Application Ref:	3/2021/0539	 Ribble Valley Borough Council www.ribblevalley.gov.uk
Date Inspected:	07/06/2021	
Officer:	RB	
DELEGATED ITEM FILE REPORT:		APPROVAL

Development Description:	Conversion of garage to additional living accommodation with mezzanine level, single storey extension and Demolition of existing outbuilding to be replaced with new detached double garage. Resubmission of 3/2020/0770.
Site Address/Location:	Ravenswing Farm, Further Lane, Mellor BB2 7QB

Site layout plans 1:250 @ A3

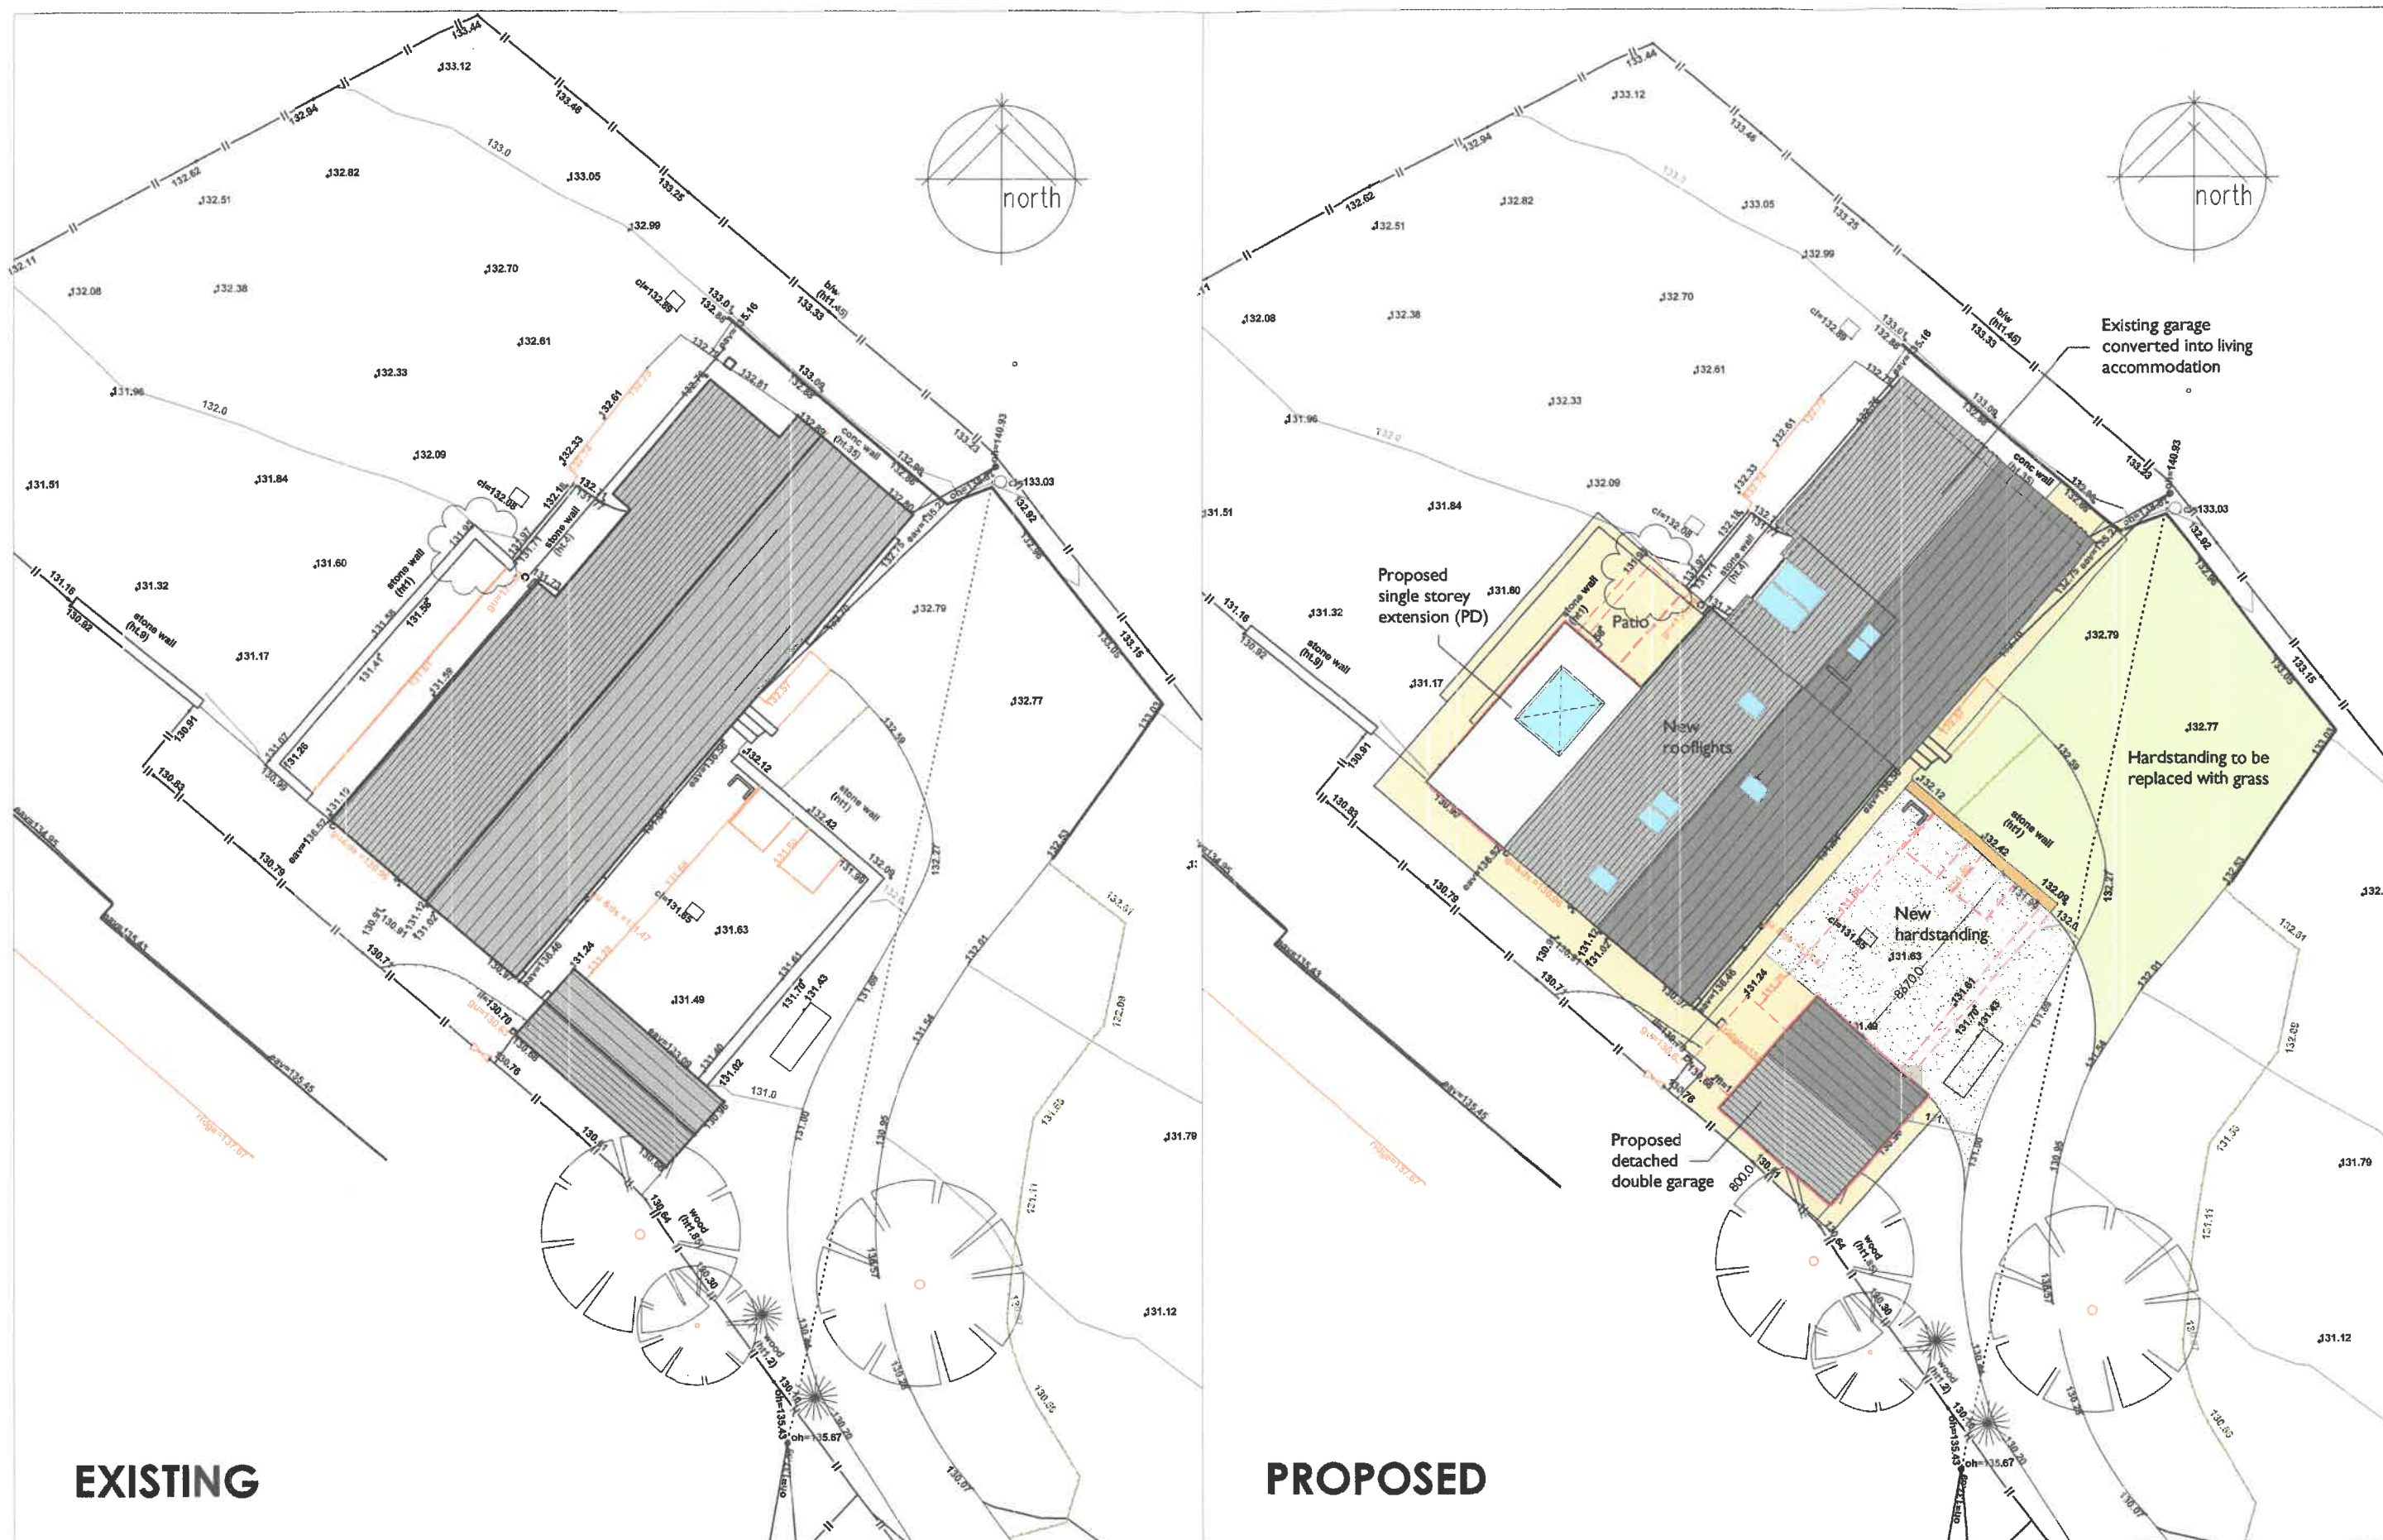
The development would result in the loss of two parking spaces as a result of the garage conversion. However, as a detached double garage is proposed and the site has sufficient space for additional off street parking it is considered that there is a sufficient number of parking spaces for a 5 bedroomed property.
